CITY OF ALBUQUERQUE

RE: **Marriot Suites at Winrock**
2100 Louisiana Blvd NE
Conceptual Grading and Drainage Plan Stamp Date: 10/25/19
Hydrology File: J19D058I

Based on submittal received on 10/25/19, the Grading and Drainage Plan cannot be approved until the following corrections are made:

GRADING PLAN

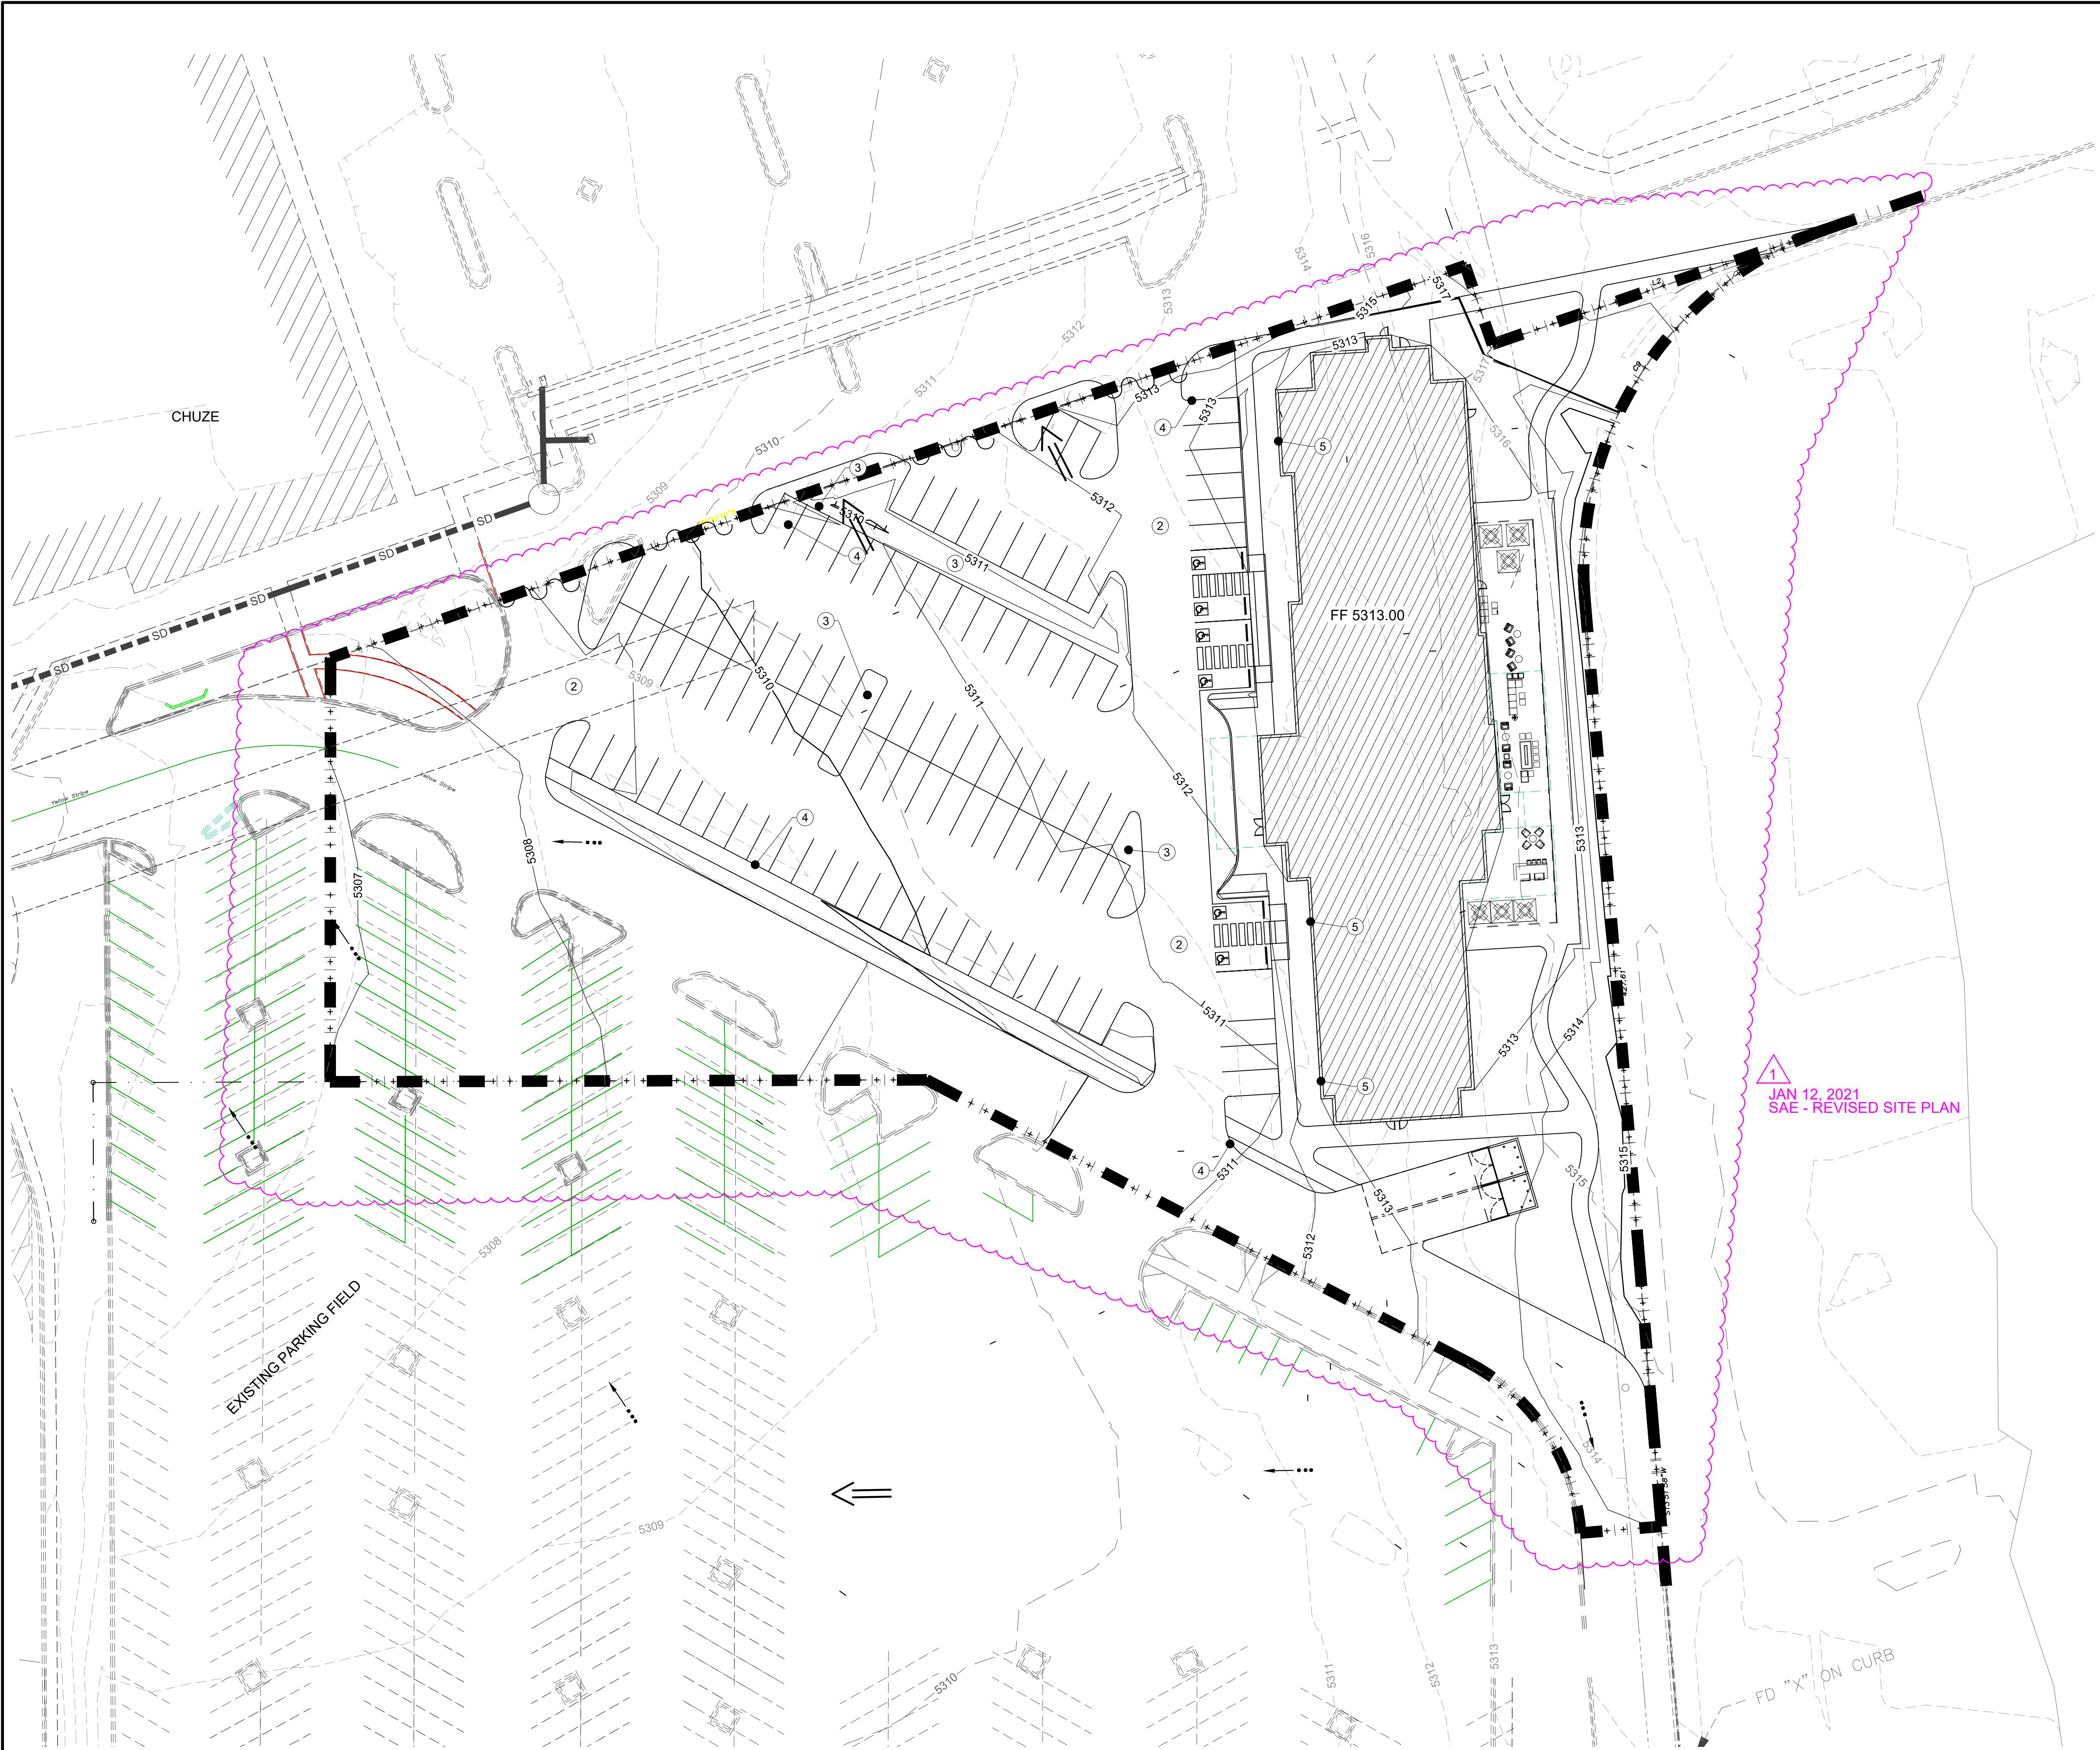
1. Please provide the stormwater quality volume (SWQV) calculations for each basin draining to each pond. The stormwater quality ponds need to be sized for the areas draining to them. Additionally, large portions of the site do not appear to drain to any pond.

5. The land treatments in the existing and proposed hydrology calculations are not reflective of the site and the proposed work.
6. Additional detail, per the DPM Ch. 22.7 *Grading Plan Checklist*, is required:

- a. Discussion and impacts of upstream offsite flows are missing.
 - b. Proposed contours are rough and seem to ignore curbs, waterblocks and other site features.

- c. Drainage features such as curb cuts, rundowns, roof drains, etc... should be identified at this stage; specific hydraulic calculations and exact locations may be deferred to Building Permit.
